Appeal Decision

Appeal Ref: APP/R5510/D/21/3269199

19 Lawn Avenue, West Drayton UB7 7AQ

- The appeal is made under section 78 of the Town and Country Planning Act 1990 against a refusal to grant planning permission.
 - The appeal is made by Mr H Virk against the decision of the Council of the London Borough of Hillingdon.
 - The application Ref 75358/APP/2020/4075, dated 8 December 2020, was refused by notice dated 1 February 2021.
 - The development proposed is "Double storey Side Extension and Part single and Part Double storey Rear Extension".
-

Proposed Elevations

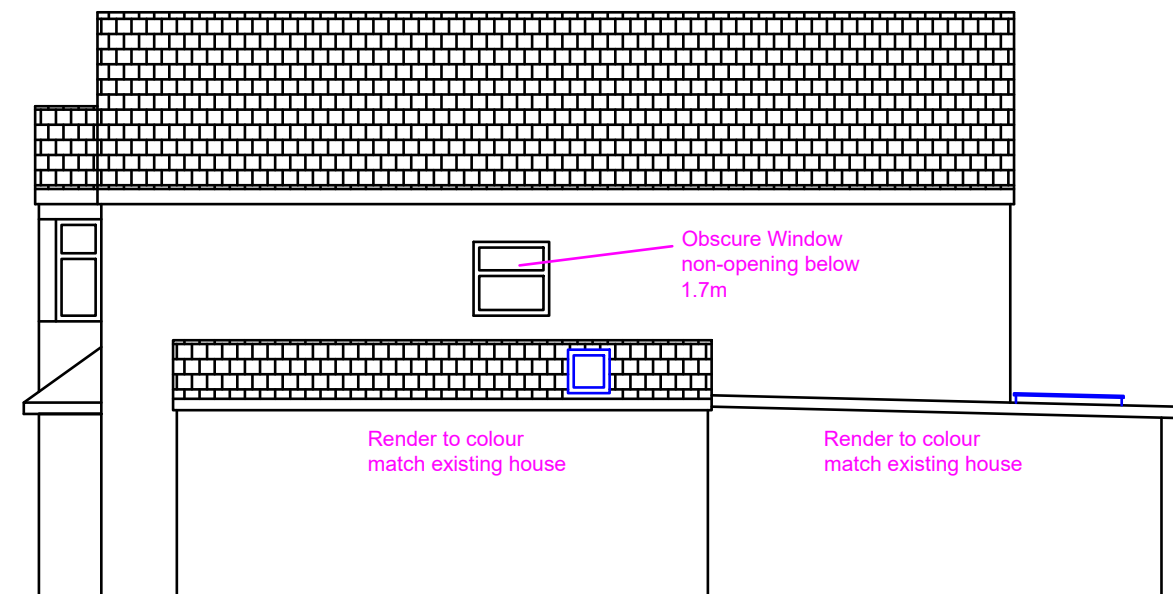
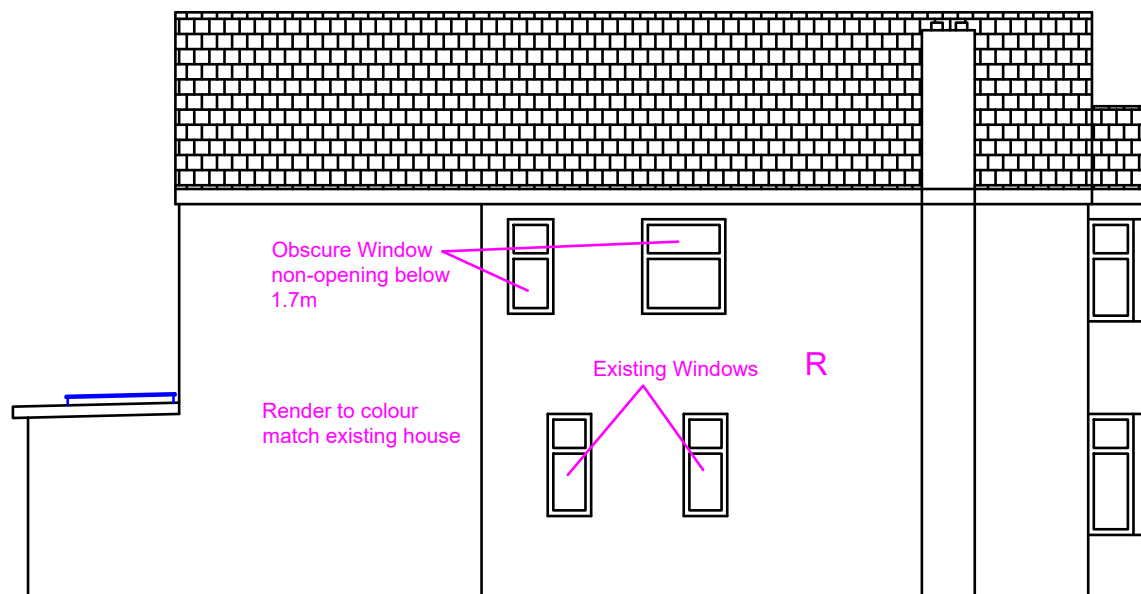
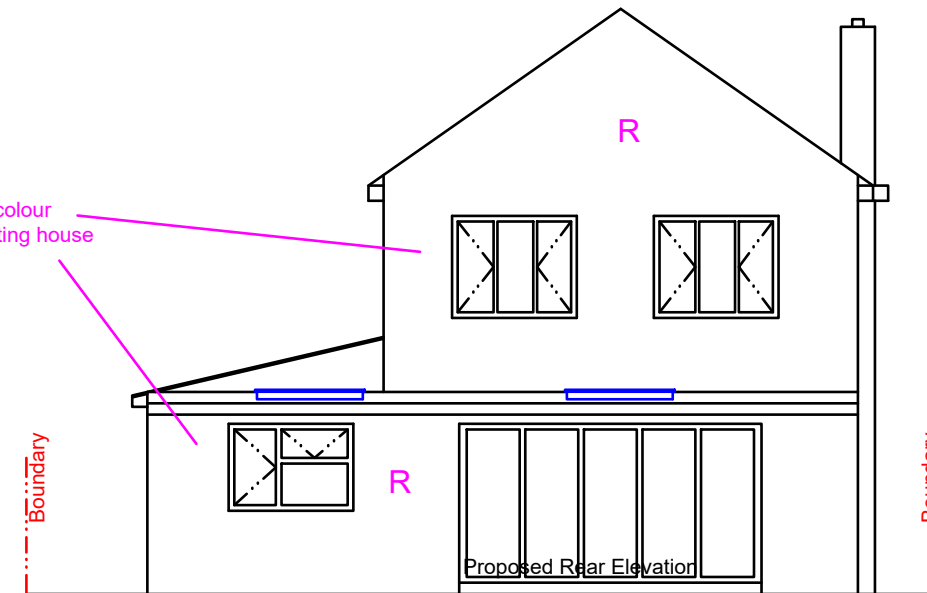
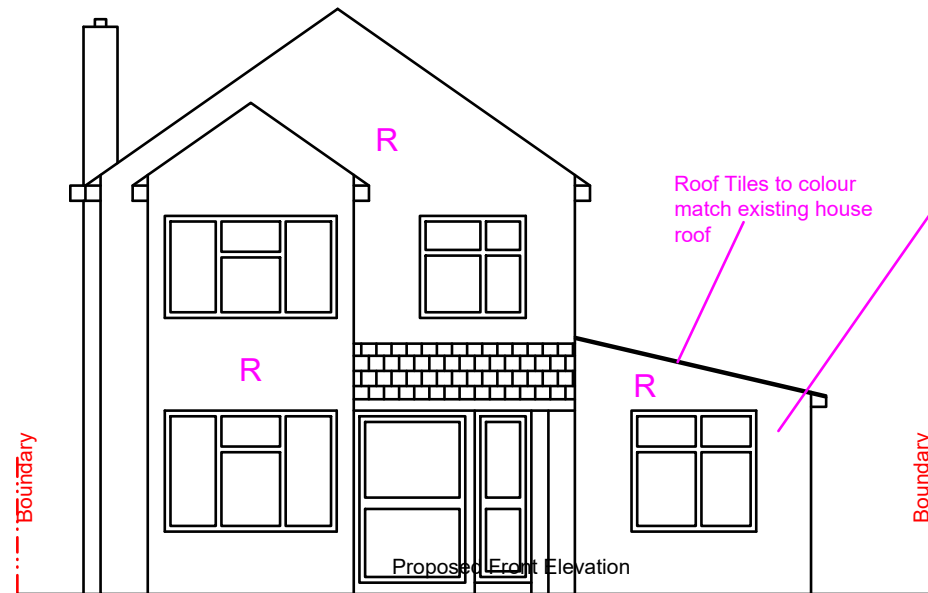
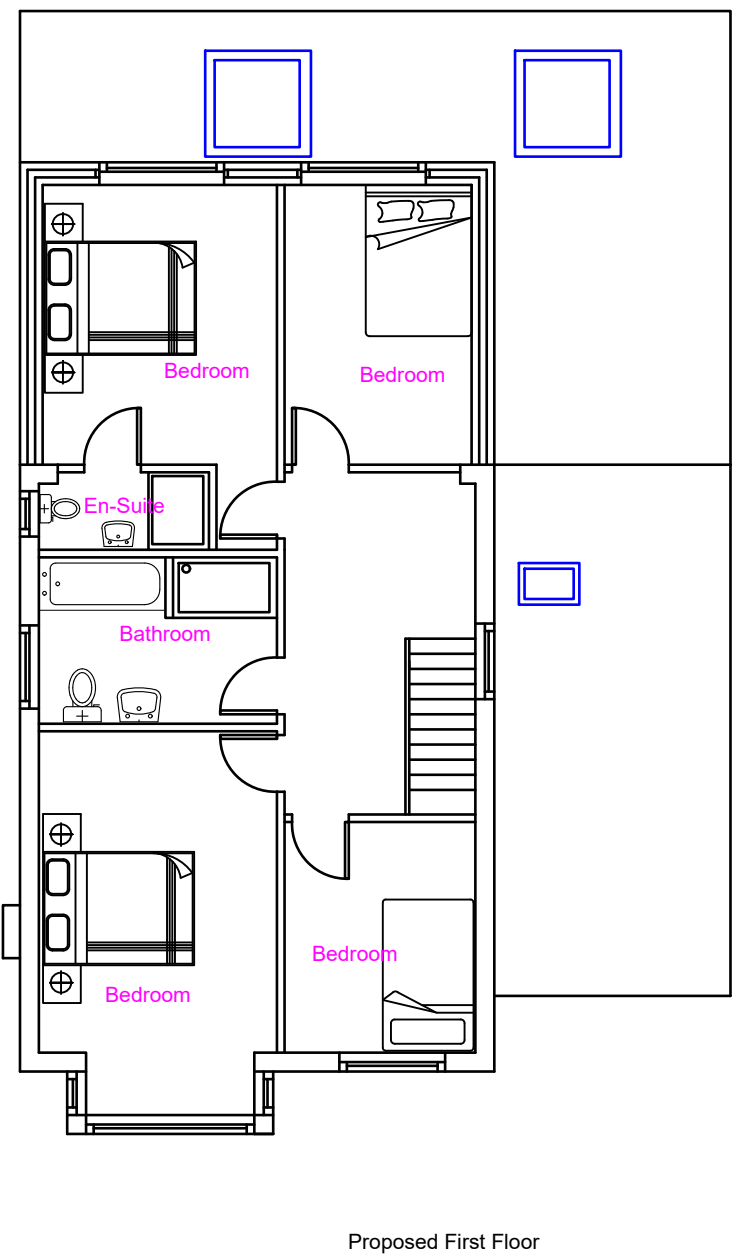
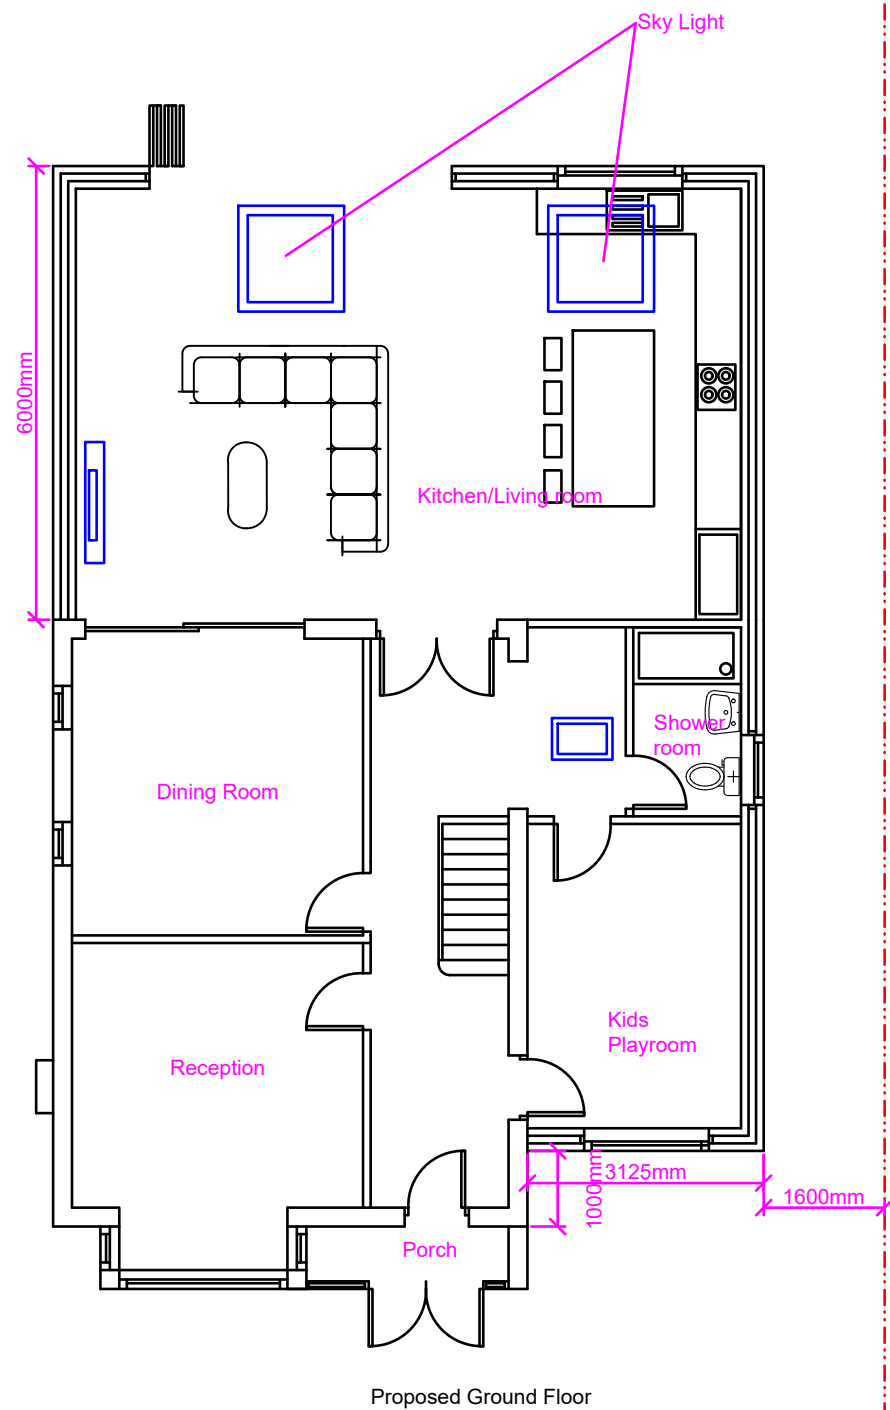
5. The single and two storey rear extensions that form part of the proposal already benefit from planning permission under a different scheme, which included a single storey side extension. The Council's objection to the proposal therefore relates to the two-storey side extension, which comprises a catslide roof following the existing roof plane with a side facing dormer.

6. The two-storey side extension would be set back from the front elevation of the house, with the dormer set in further from the front and rear elevations and back from the eaves. It would otherwise stretch the full width of the proposed

extension, with four side facing windows shown on the submitted plans to be obscure glazed.

7. Notwithstanding the presence of side facing dormers of various designs in the locality, the proposed dormer would be of poor design, adding uncharacteristic bulk to the appeal building which would be out of scale with the roof slope of the neighbouring house along this side boundary and entirely noticeable in the street scene. The side elevation of the proposed dormer would be utilitarian in appearance on account of the four obscure glazed windows, which would also be appreciable in views from the street. This would emphasise its awkward relationship with the neighbouring property and lack of quality in design, which would not relate well to the pleasant residential character of the area. The proposed dormer would therefore cause unacceptable harm to the character and appearance of the area.
